**CITY OF ALBUQUERQUE
PLANNING DEPARTMENT
March 25, 2015
DRB Comments**

PROJECT # 1002321

APPLICATION # 15-70116

RE: Lots 5-7, Journal Center Phase 2

# SKETCH PLAT FOR JOURNAL CENTER PHASE 2, UNIT 2

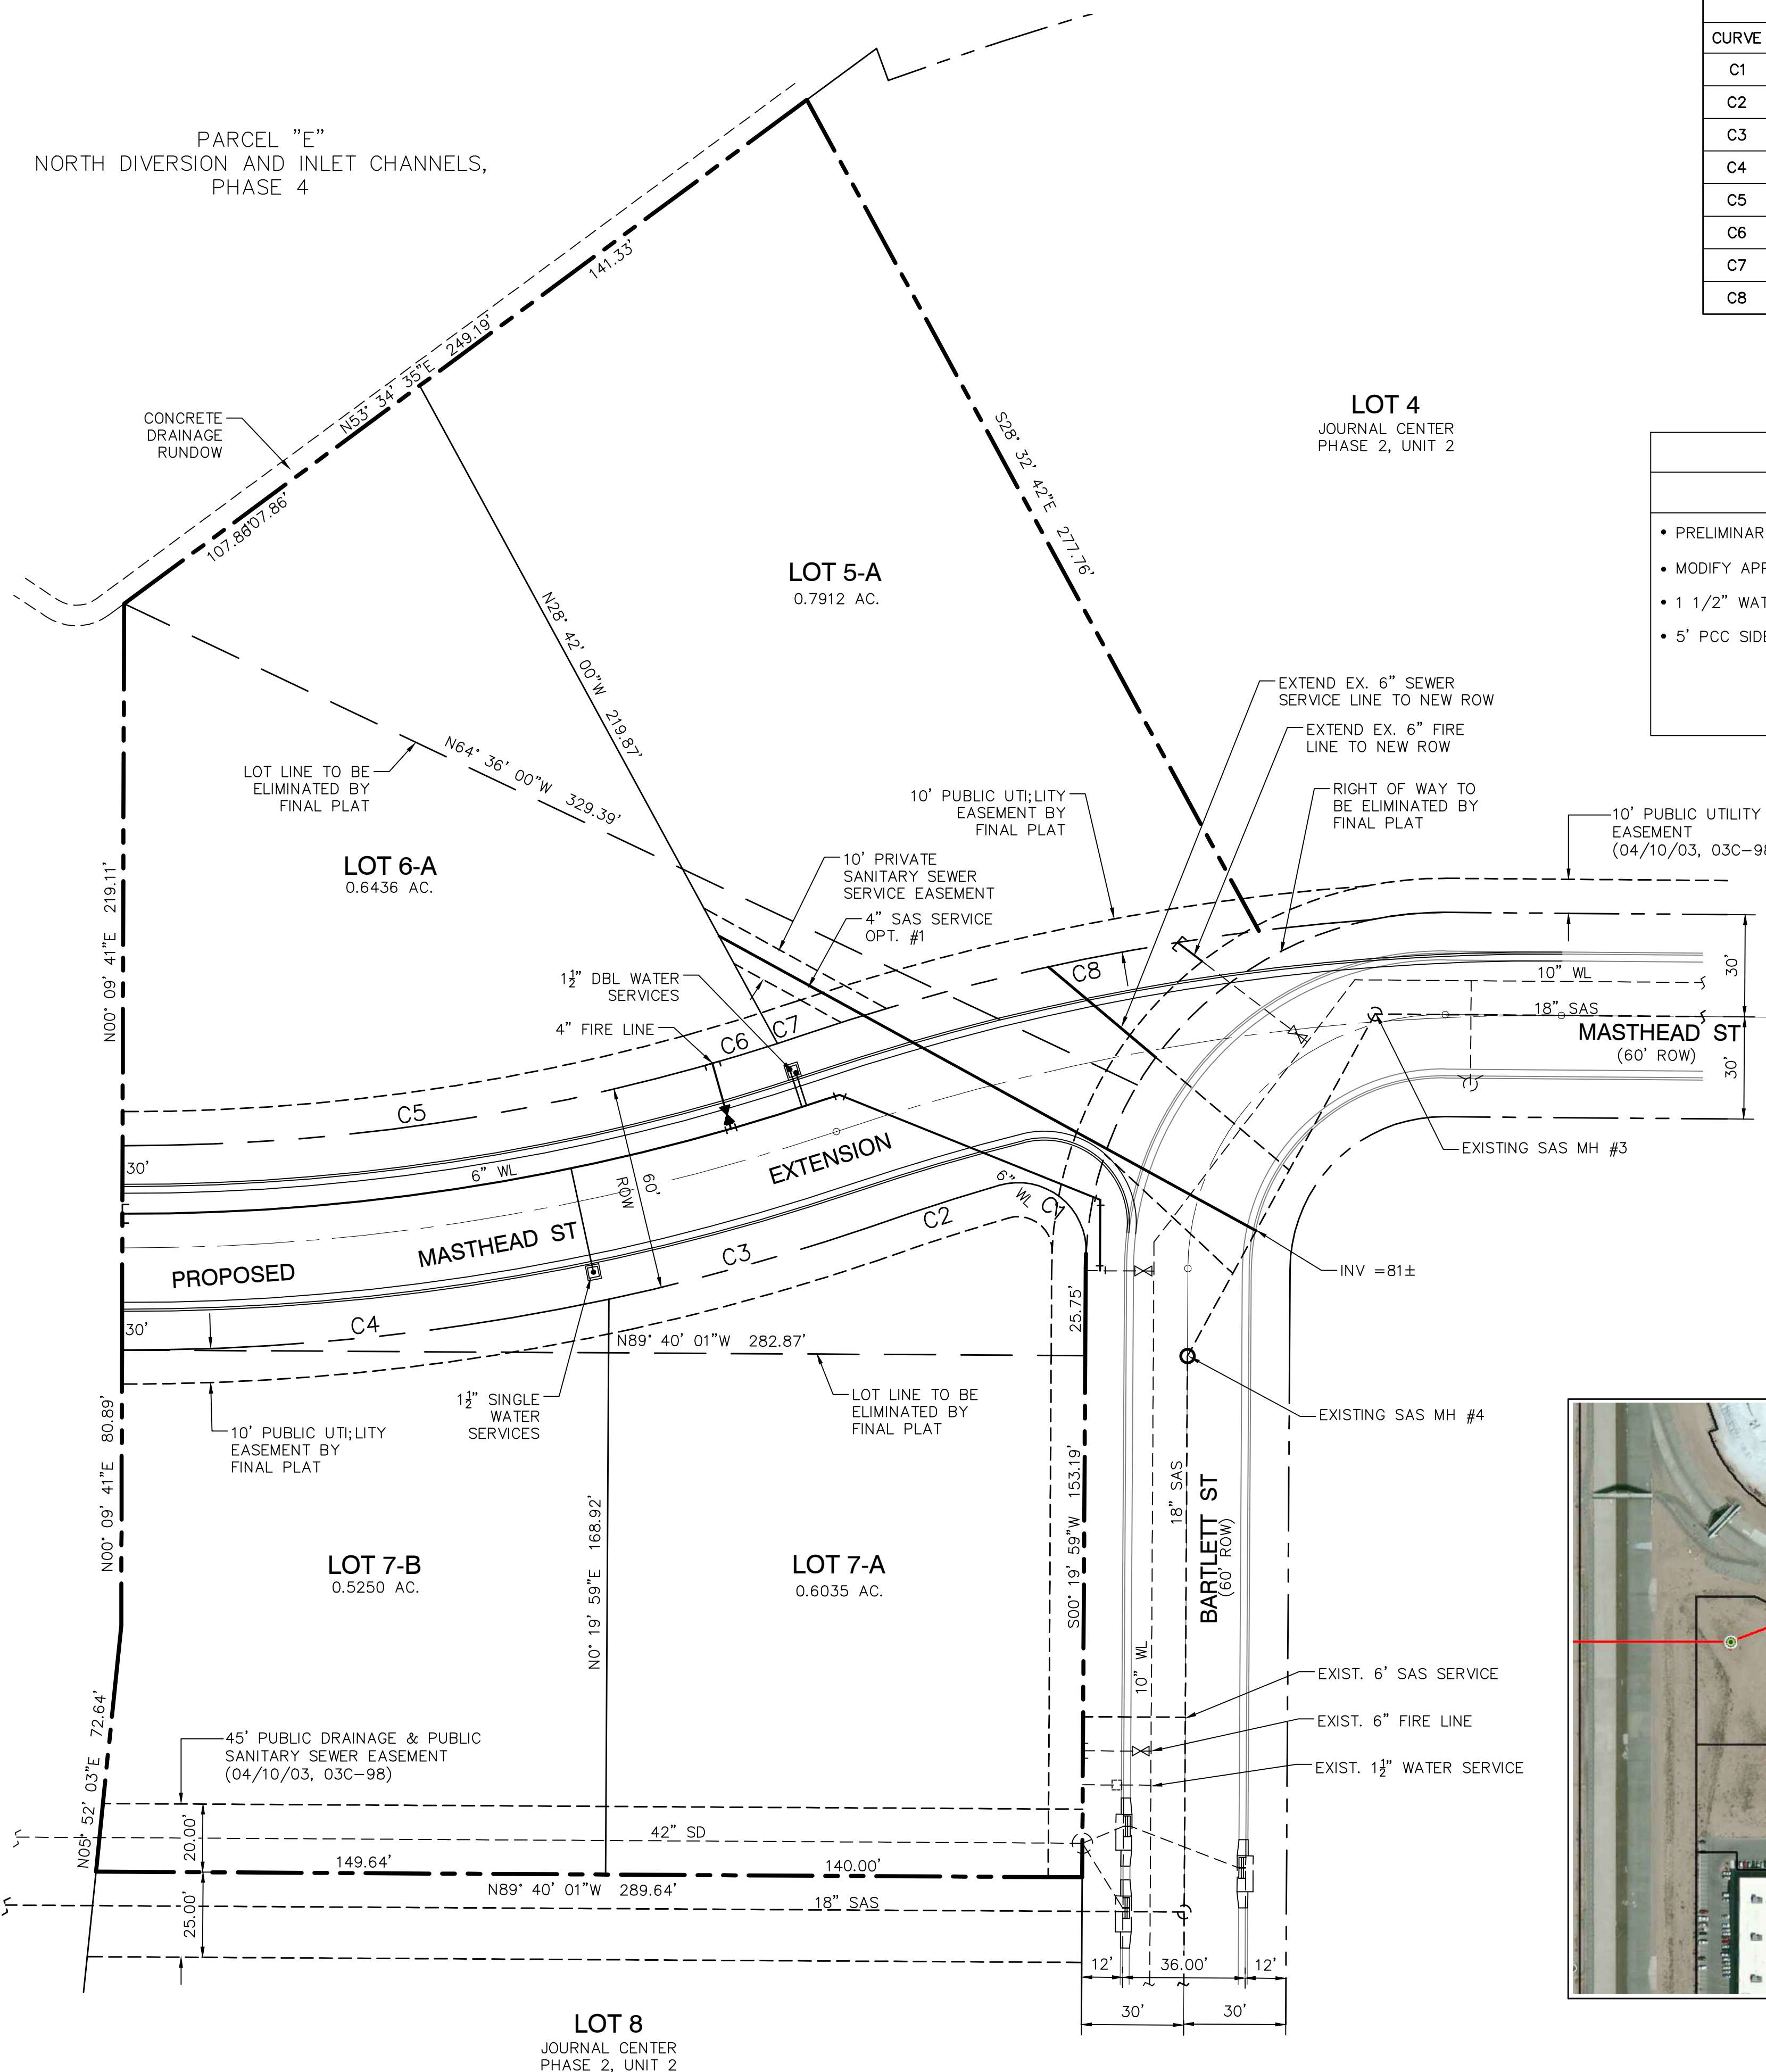
The note 'RIGHT OF WAY TO BE ELIMINATED' is not correct – additional right of way will simply be added to existing. If additional right of way is not being dedicated by plat, confer with the City Attorney for appropriate designation of what will be the 'street' tract.

A vehicular turnaround or connection to public right of way will be needed with appropriate public easement.
